Your Ref: OWPC24765
Our Ref: AL/81/19/PL 23-09-2019
Please ask for:
Mr S Davis

Replacement bungalow
D2 Paddock View Northfields Lane Aldingbourne

Thank you for your internet representation made on 6th November 2019 which has been recorded as '**no objection**' with the comments as follows:

EAST ELEVATION

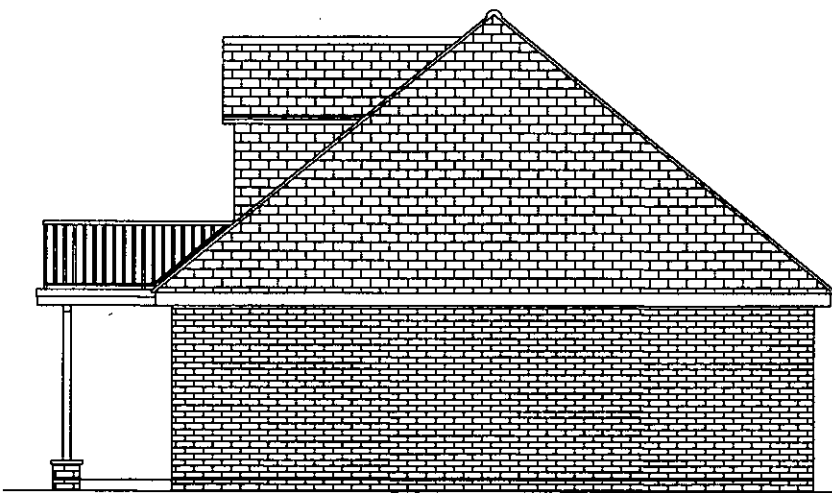
However, I am concerned that the plans of the intended build are showing on the East Elevation a window overlooking into the property/garden of 'Mount Pleasant Cottage'. This intention interferes clearly with privacy of the property owners. Therefore, these plans should aim to demonstrate improved omniscience of potential impact. Amendment is required. The plans need to show no windows (Velux or other) for this intended build on the East Elevation overlooking into the garden of Mount Pleasant Cottage. It must also be stated as a condition (if the plans are accepted following amendments) that no further modifications to this or any future planning application can allow the possibility of windows to the East Elevation to be authorised. Thank you. I hope that you agree this reasonable amendment is necessary before any possible authorisation is granted.
